Our Ref: H/2/12/L

23rd February 2012

**Application for Listed Building Consent for various internal alterations & renovation of existing hardwood, double-glazed conservatory (this application lies within the South Downs National Park Authority)
2 St Nicholas Cottages The Street Houghton**

SCALE 1:1250
LOCATION PLAN

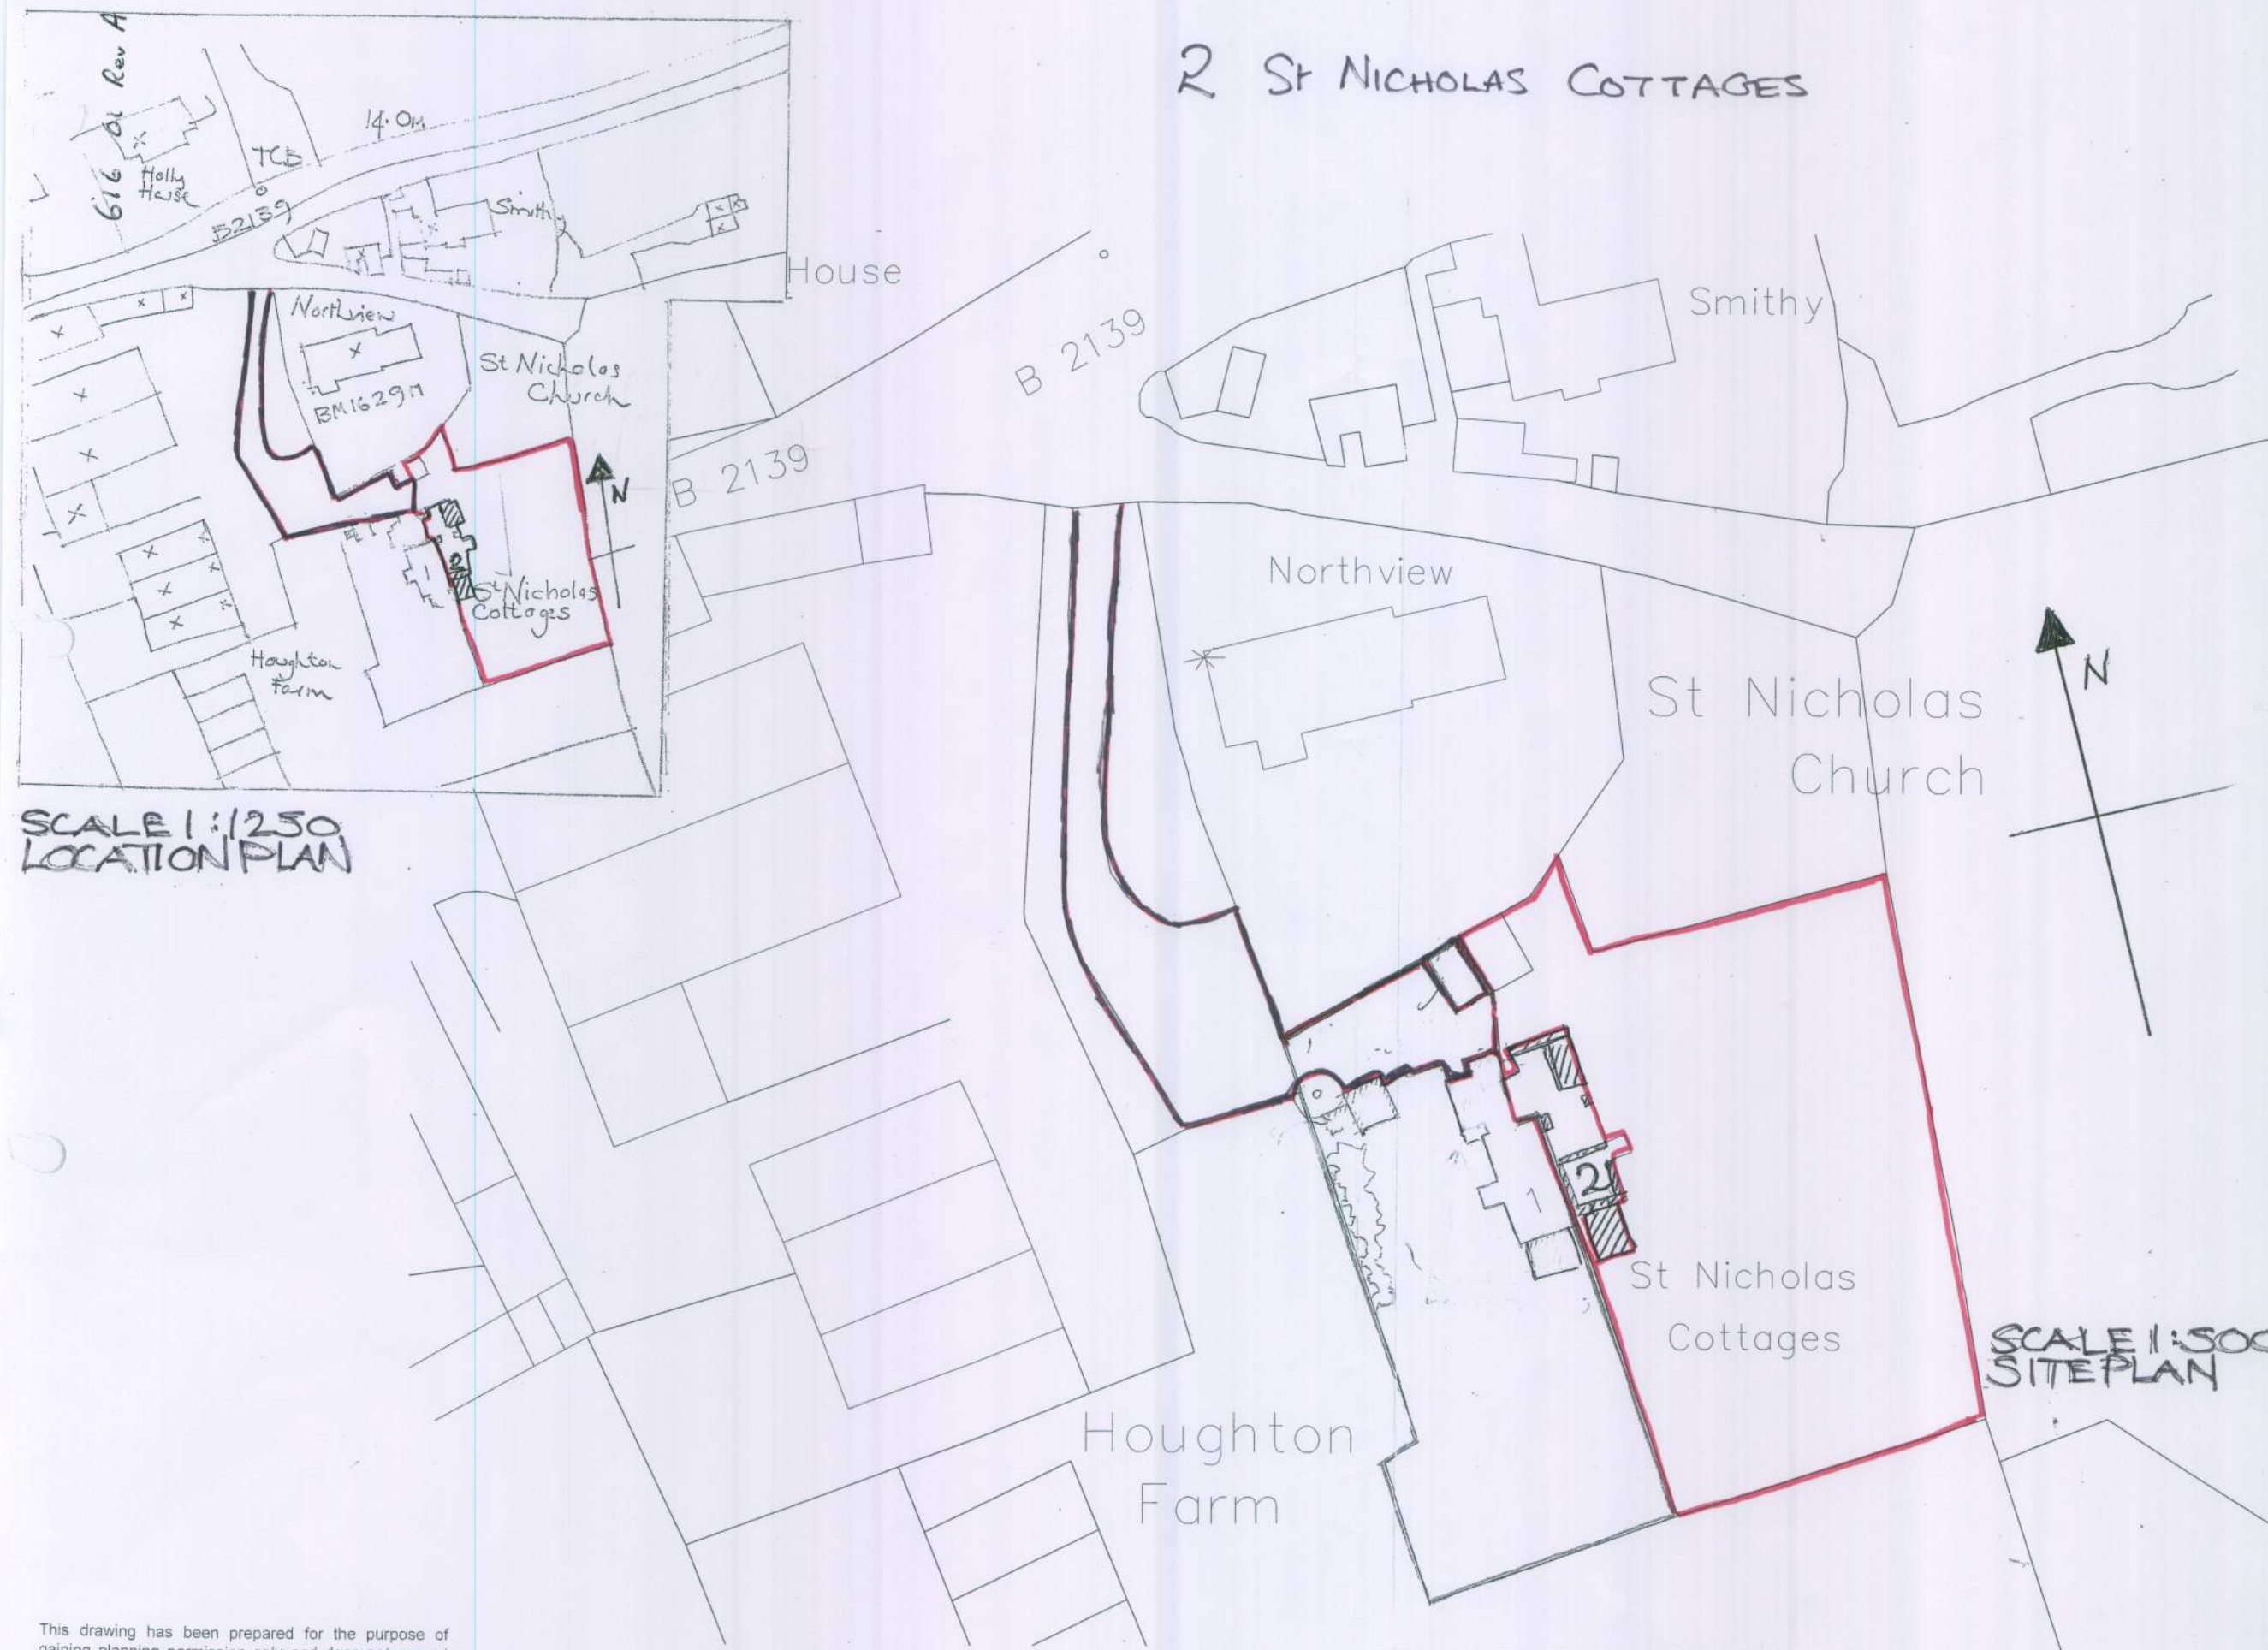
I require 1 electronic or 3 paper copies of a revised block/site plan, showing a north point and the position of all the proposed works, in accordance with the guidance notes available on our website detailed below (click on National List).

I require 1 electronic or 3 paper copies of a revised location plan showing a north point in accordance with the guidance notes available on our website detailed below (click on National List).

2 St Nicholas Cottages
Proposed floor plan 2012
Scale 1:50
Ref: H/2/12/L
Renovation + alteration
Mr and Mrs. S Smith

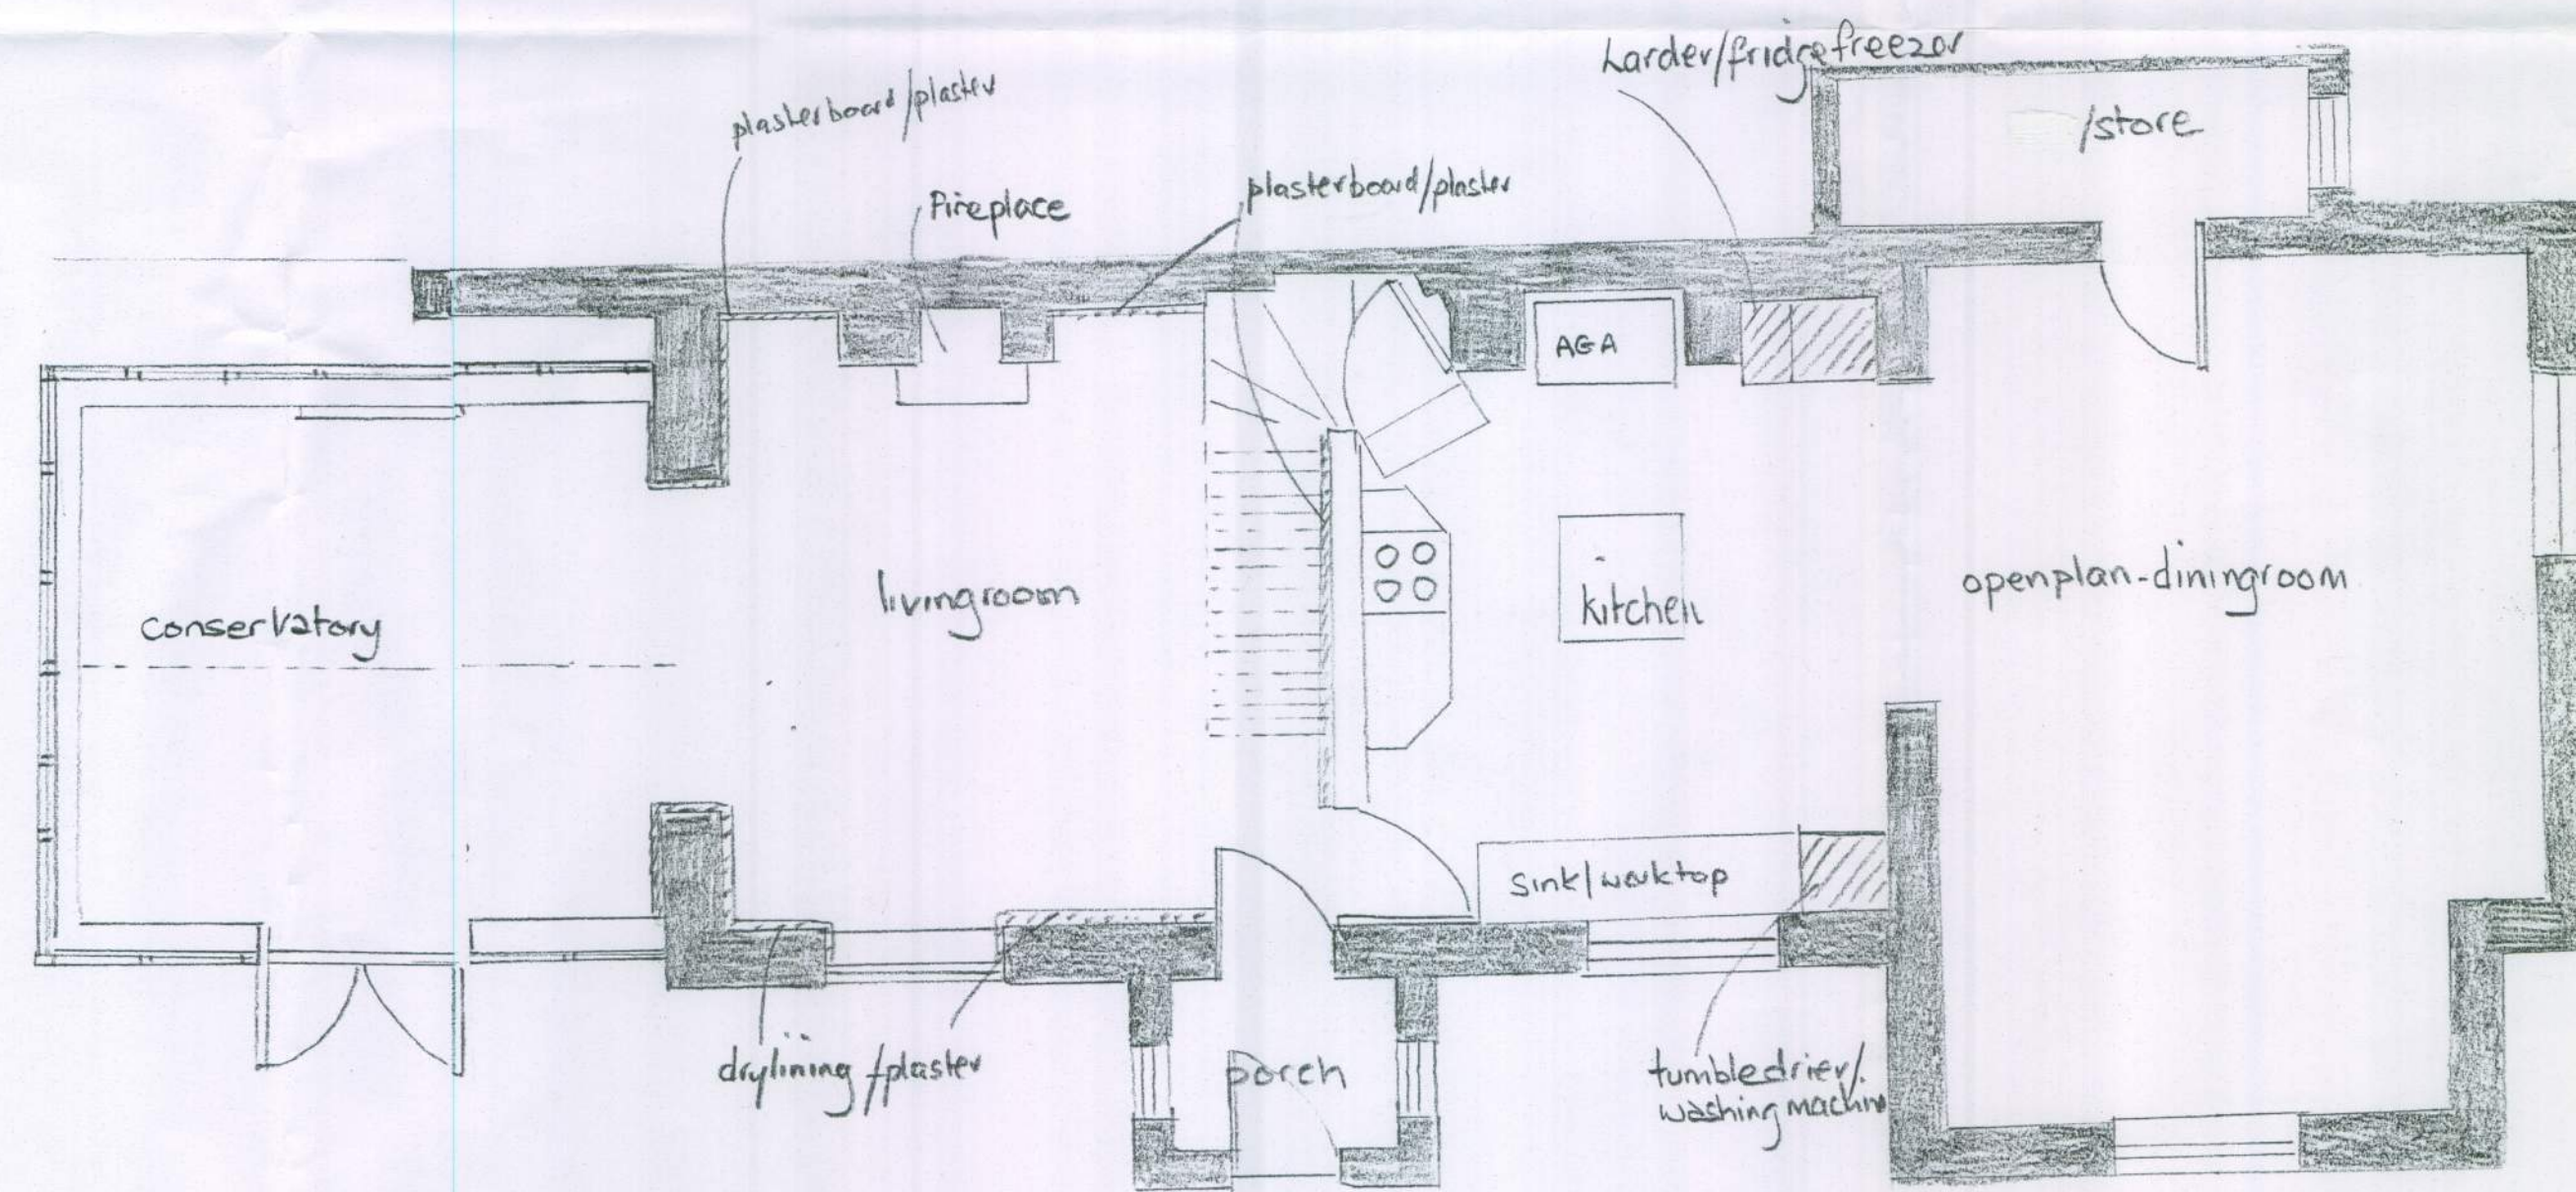
Please provide 1 electronic or 3 paper copies of existing and revised proposed floor plans at a scale of 1:50 or 1:100 relating specifically to 2 St Nicholas Cottages. The plan provided appears to show works to 1 St Nicholas Cottages.

ENLARGED OPENING FORMED BETWEEN
CONSERVATORY AND LIVING ROOM AT N° 2, ST NICHOLAS
COTTAGES, HOUGHTON BN18 9LW. SCALE 1:50 3RD APRIL 2012

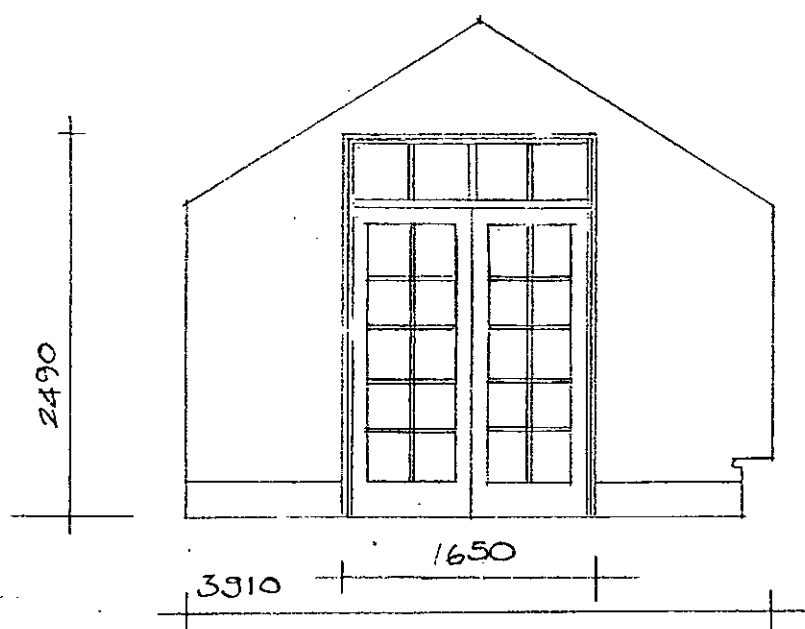
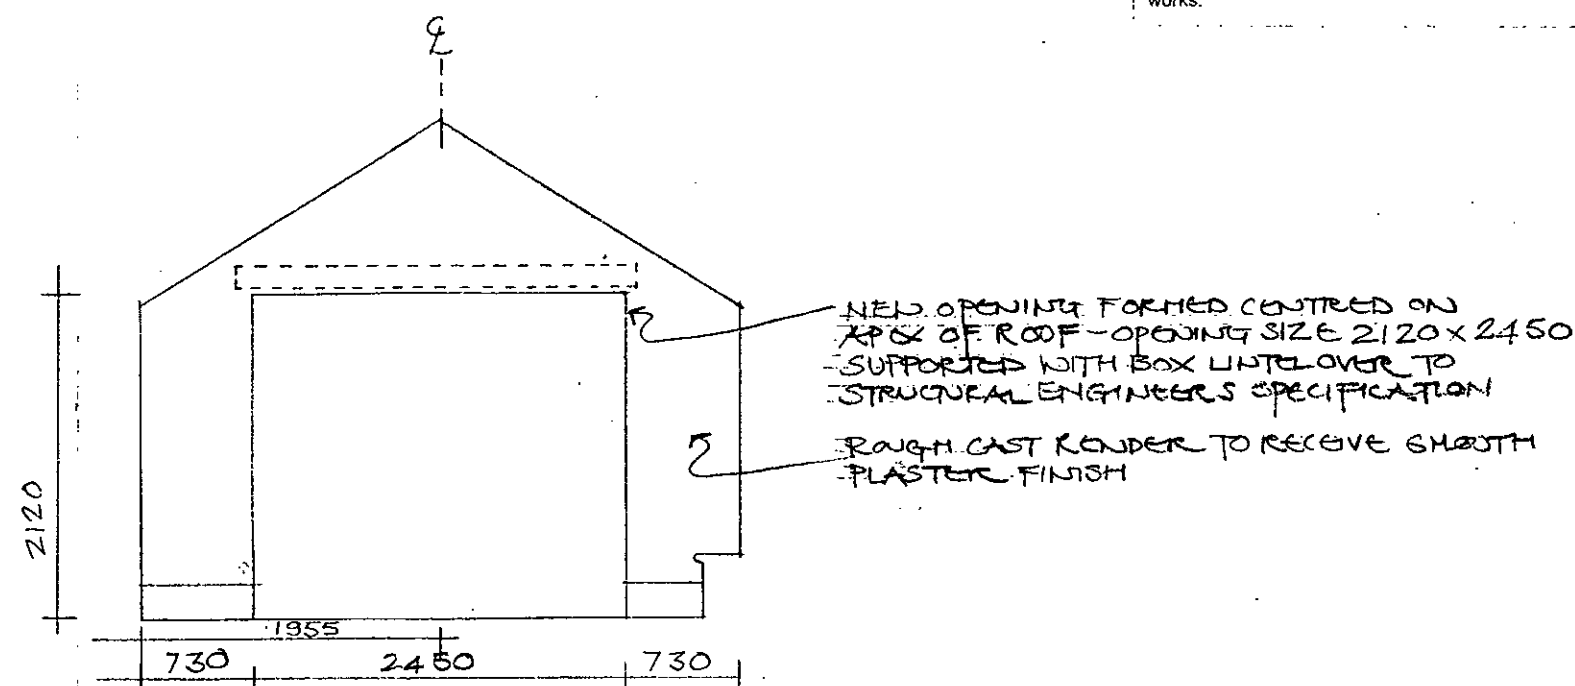
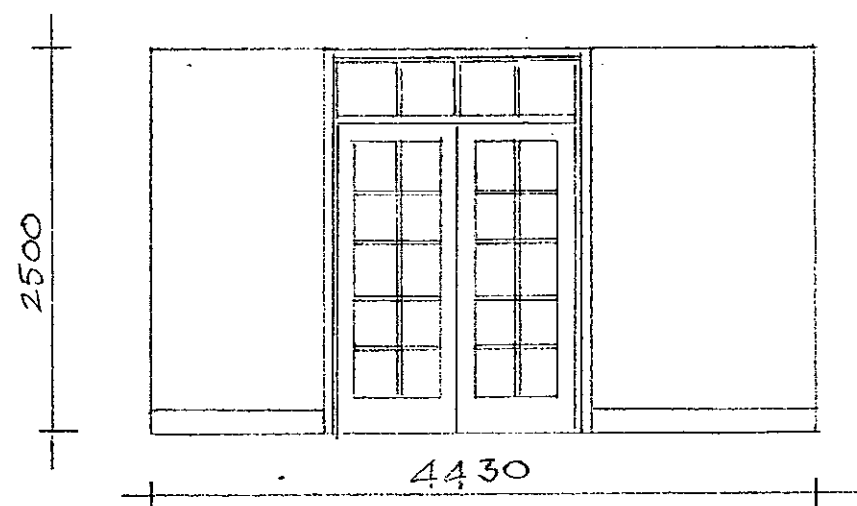
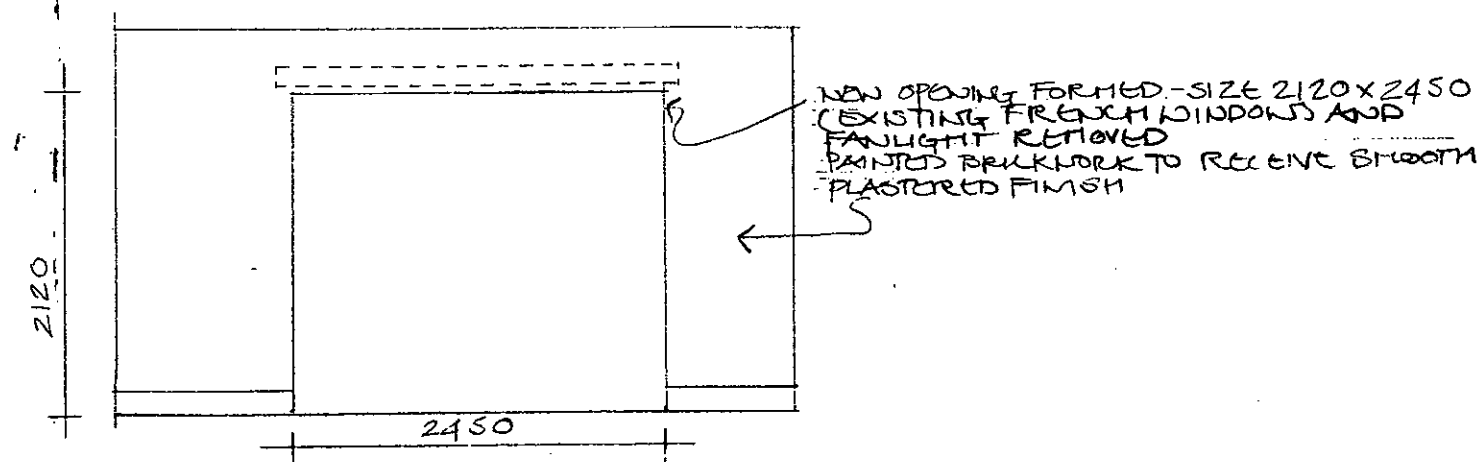
Following on from my site visit today I request clarification of the proposed opening treatment to the living room from the conservatory. I note you wish to widen the opening and fill in the upper portion of the opening. I have briefly spoken to the Historic Building Advisor who has advised that the removal of this doorway and change in proportions may not be acceptable. I would therefore appreciate receipt of an additional scaled elevation plan to clarify your intentions regarding this opening so that a full assessment can be made of your proposals.

Following on from the receipt of your additional information I have now received the comments of the Historic Buildings Adviser who has stated that he has no particular concerns over the conservatory or the removal of the stud wall, but there is an issue with the widening of the original wall into the conservatory. At present this opening reflects the width of the French doors which is normally an appropriate size for a breach. Any opening beyond this can impact on the building plan but more importantly the can alter the character of the historic space and result in the loss of historic fabric. In accordance with English Heritage guidance these types of harm should be kept to an absolute minimum.

I therefore request that this element of your proposal is deleted from the application. If it remains part of the application then I would advise that it is likely the application will be refused in relation to the adverse impact of this part of your proposal on the Listed Building.

Further to your recent discussion regarding the proposed opening treatment to the Living Room from the Conservatory, I have now measured the wall in question and enclose herewith a scaled drawing of the proposed reconfigured opening. I trust that you will find this in order, but should you require any additional information, please do not hesitate to contact me.
